**FOSSE GREEN ENERGY DEVELOPMENT CONSENT ORDER**

**PINS REFERENCE EN010154**

**DEADLINE 3: NATIONAL HIGHWAYS'  
RESPONSES TO EXQ2**

SECURITY GATE
Scale 1:50 @ A1

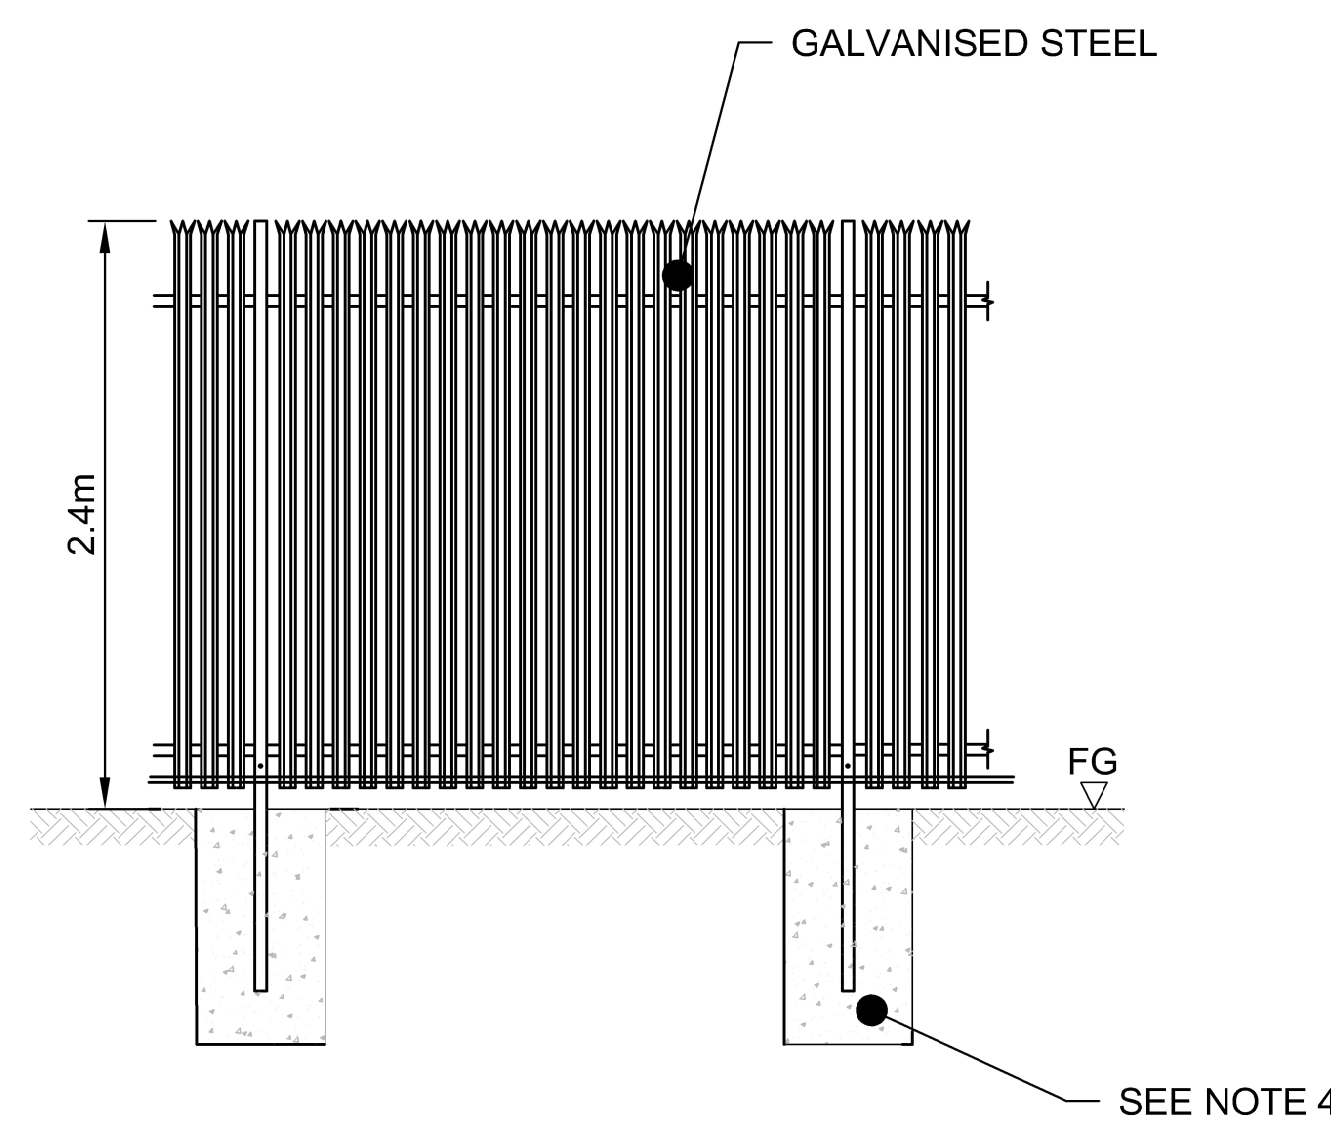
<u>Question number</u>	<u>Question to</u>	<u>Question</u>	<u>National Highways response</u>
DCO.2.15	National Highways	<p><b>Requirement 9 (Fencing and other means of enclosure)</b></p> <p>In [REP2-052] you have advised further information is required on the proposed fencing and other means of enclosure before you can confirm your position with respect to Requirement 9.</p> <p>On pages 35 and 36 of its post hearing summaries in [REP2-032], the applicant signposts the fencing details and identifies that the FCEMP was updated at Deadline 1 to confirm that any fencing would be located behind existing hedgerows adjoining the A46.</p> <p>a) Does the information provided in [REP2-032] address your concerns about fencing and other means of enclosure?</p> <p>b) If not, would you want the applicant to submit further details during the examination (and if so what) or would being added as a consultee to Requirement 9 address any remaining concerns about fencing and other means of enclosure you have?</p>	<p>NH has reviewed the documentation submitted by the Applicant at deadline 1 and is now satisfied with the proposed fence locations.</p> <p>These appear consistent with Strategic road network and the delivery of sustainable development Circular 01/2022 requirements. Therefore, NH no longer seeks to be consulted on Requirement 9.</p> <p>It is noted that the proposed fence line does sit directly behind the existing hedgerow adjacent to the A46. It is possible during installation, damage could be caused to the roots of the hedgerow due to the close proximity. Should damage be caused to the hedgerow to insecurely root the plant, NH may seek to remove the hedgerow under its powers under the Highways Act 1980 should it become a safety concern and threat of falling down on the adjacent A46.</p> <p>This further support NH's request to be a named consultee on Requirement 8 Landscape and Ecological Management Plan (LEMP) of the draft DCO, which states that existing hedgerows are being relied upon for glint and glare mitigation. Therefore, any damage to these hedgerows during the installation of the fence may effect the glint and glare mitigation measures proposed in the LEMP. This would be of interest to National Highways.</p>
